OUT19/10642

**Marulan South Limestone Mine Continued Operations Project (SSD-7009)
EIS Exhibition – Revised Response**

Liz Rogers - Manager, Assessments
Water – Strategic Relations
15 August 2019

Figure 2: Marulan Creek Dam Layout

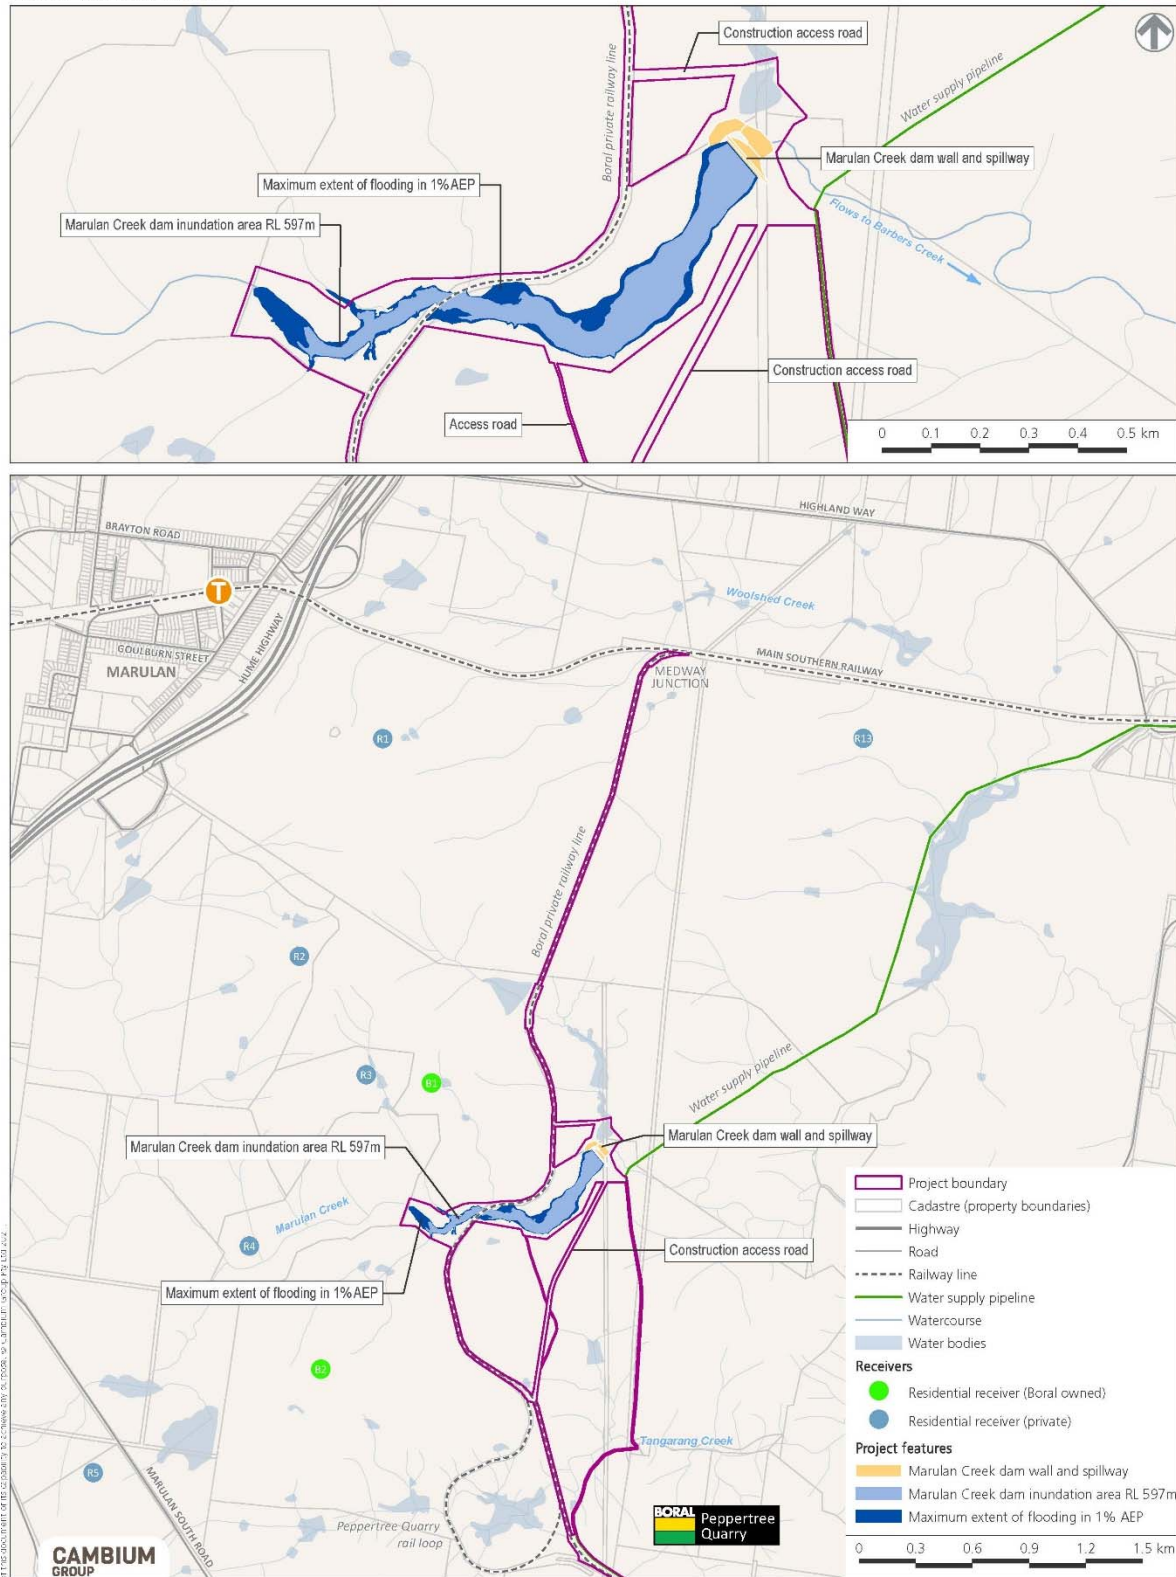
- Marulan Creek is within the Barbers Creek Management Zone, where new in-river dams are prohibited under Clause 62(5) of the Water Sharing Plan (WSP) for the Greater Metropolitan Unregulated River Water Sources 2011. **Attachment A** provides further comments regarding the intent of the WSP.
- Online Detention basins are not allowed in 3rd or 4th order streams, as per the Guidelines for Controlled Activities on Waterfront Land Riparian Corridors (NRAR, 2018).

The proposed dam will impact total flows downstream in Marulan Creek and into the Barbers Creek gorge and flow variability and ecological resilience within the channel and fringing zone. The EIS does not assess the likely cumulative impacts on flow dependent species, nor does it present an analysis of reducing flow variability on sediment transport or interruption of geomorphic processes in Barbers Creek. It is important that the proponent address the above objectives and performance indicators in the water sharing plan when preparing additional information to support consideration of a new dam.

- **Marulan Creek Dam Impacts and Mitigation**
 - Description of the current geomorphology, aquatic environment and ecological communities downstream of the proposed dam in Marulan Creek and Barbers Creek.
 - Management of the impacts to the above including the impact of the proposed dam on the flow regime, and geomorphic and ecological processes in Marulan Creek and Barbers Creek;
 - Consideration of managing impacts through retirement and removal of existing dams managed by Boral. This should include a discussion on the effectiveness of dam removal in mitigating the impacts of a new dam on catchment hydrology including Barbers Creek;
